## **Wildland Fire and Hazard Mitigation Plan**

### **Hidden Creek Estates Subdivision**

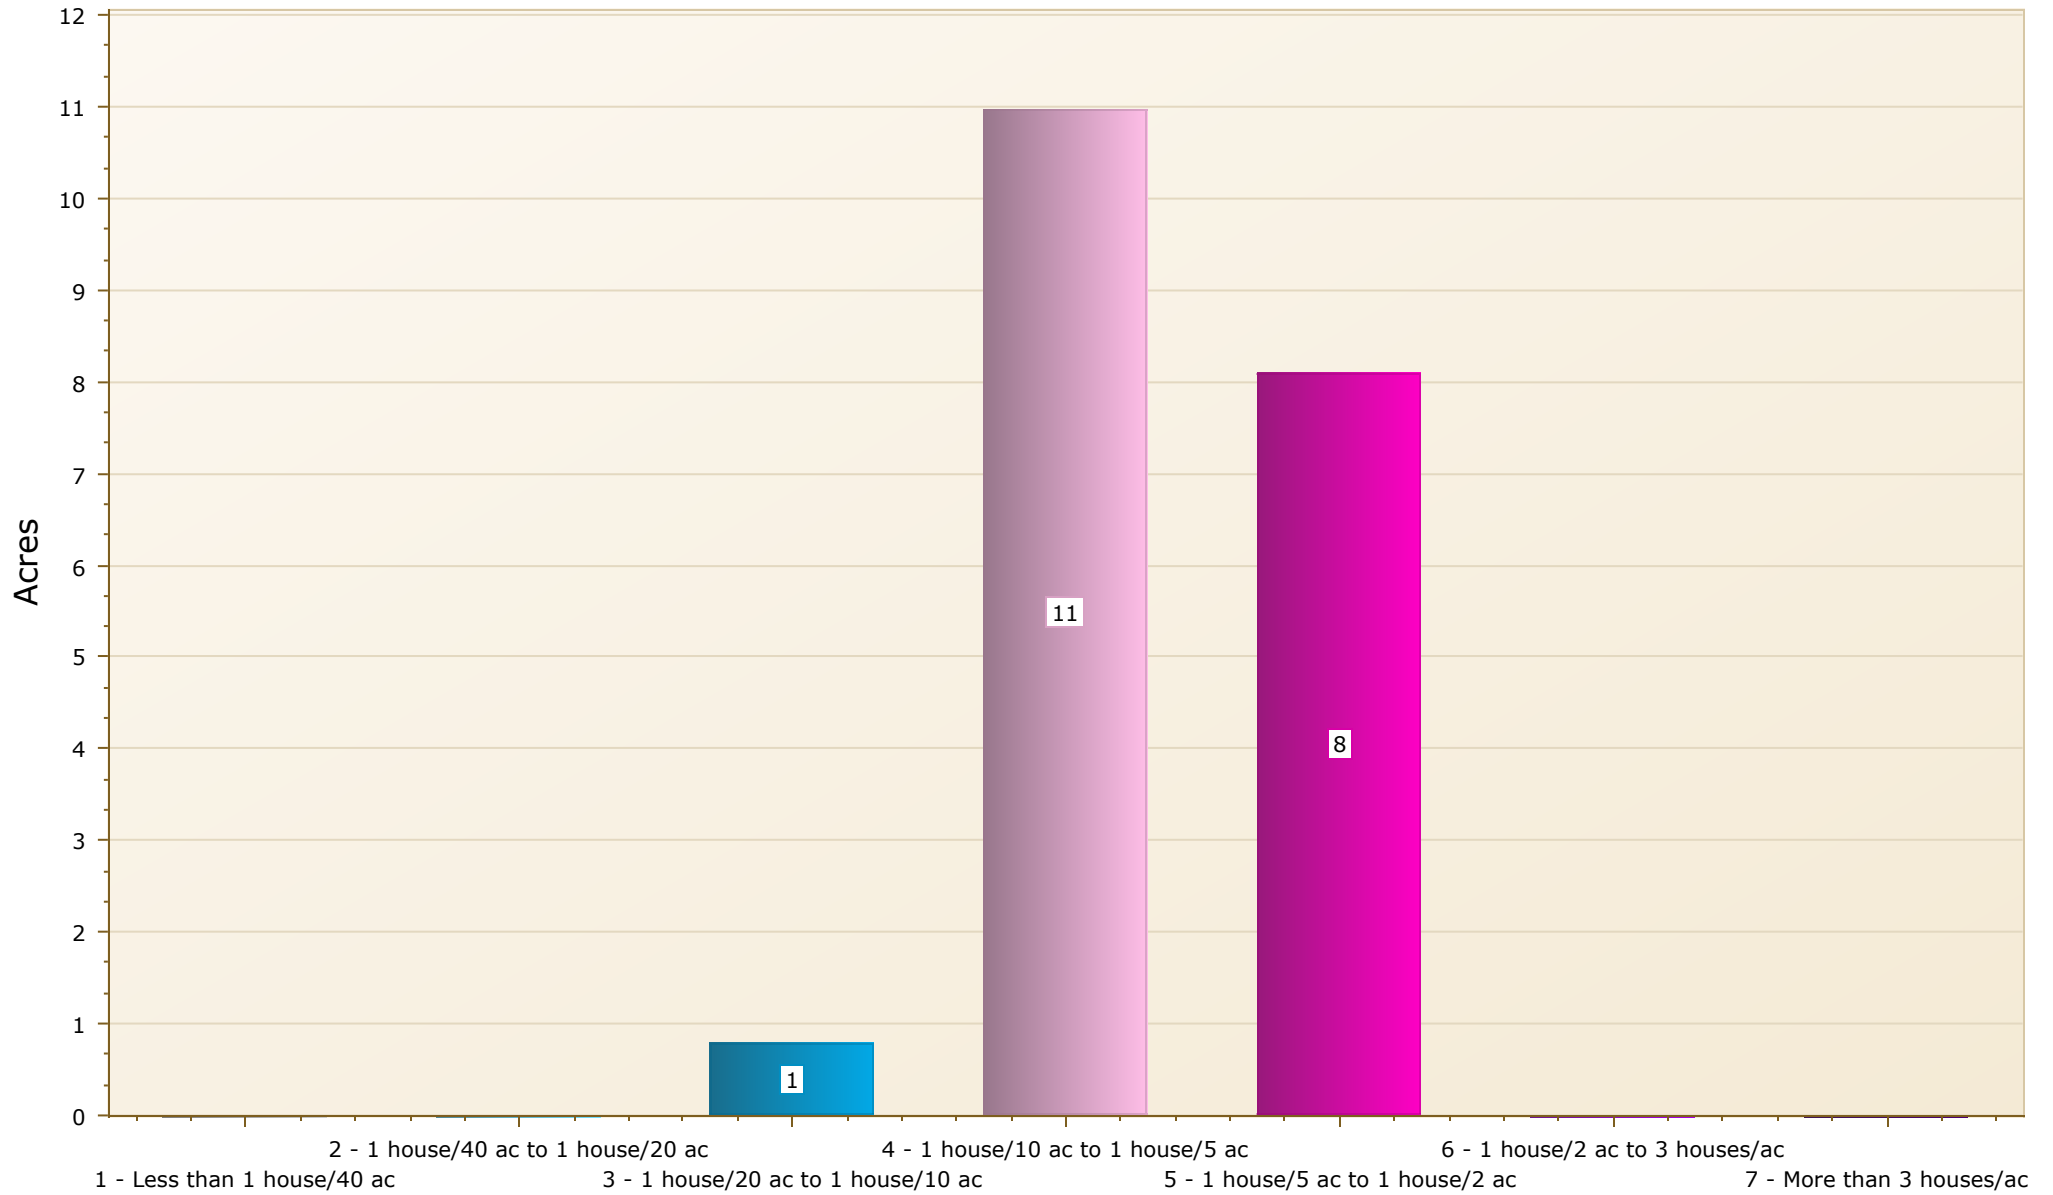
The property consists of 28.56 acres. Please include the additional 8.56 acres in your analysis of this property.

**RESPONSE: EXPLANATION  
INCLUDED TO EXPLAIN WHY THE  
SIZE DOES NOT MATCH.**

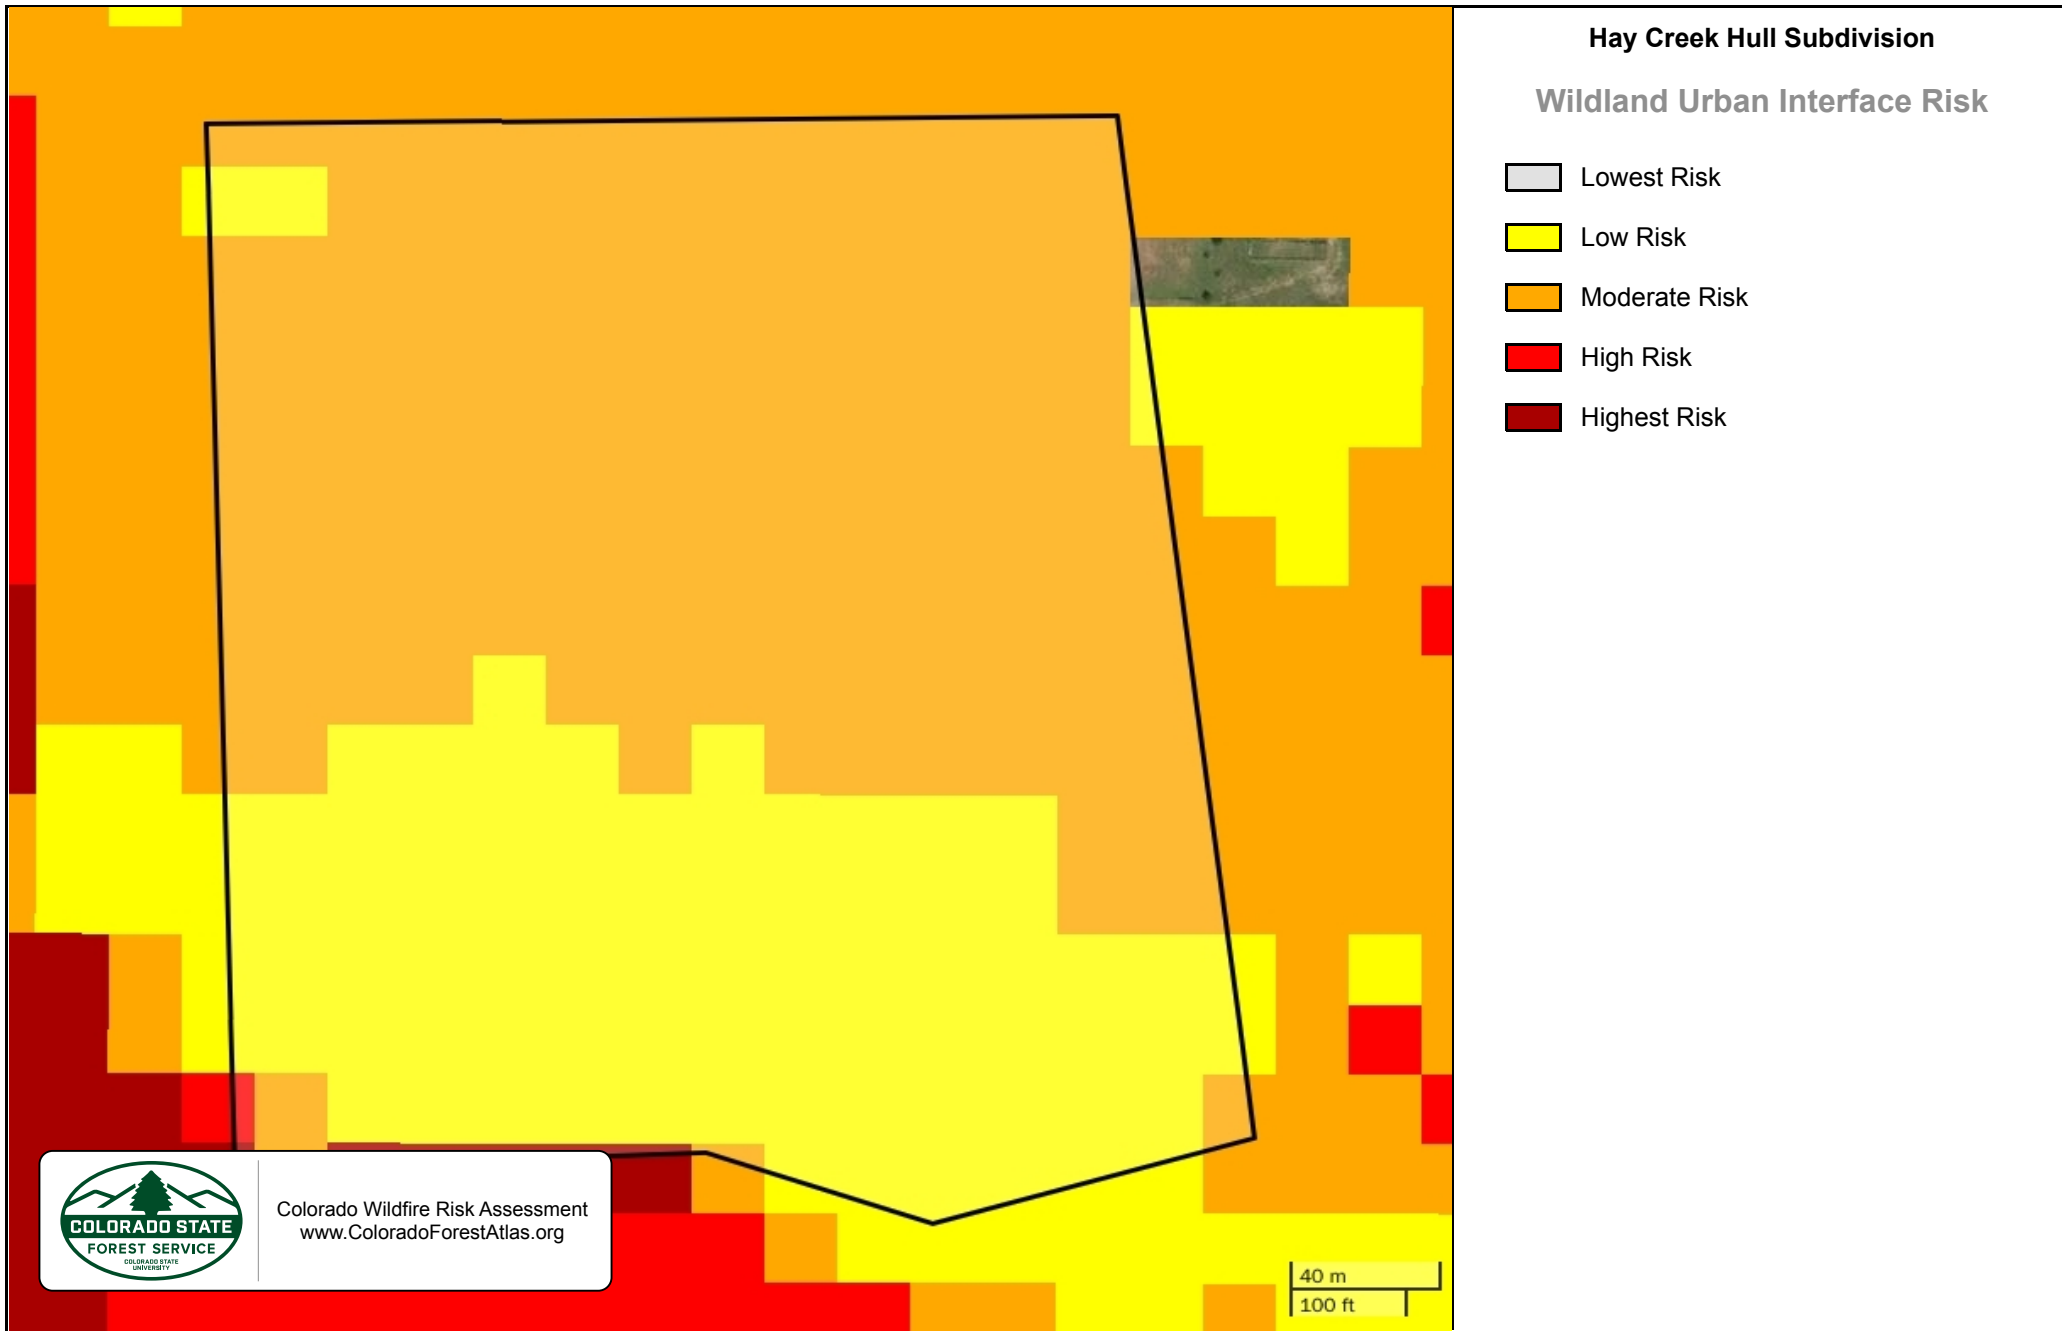
The property consists of 28.56 acres. Please include the additional 8.56 acres in your analysis of this property.
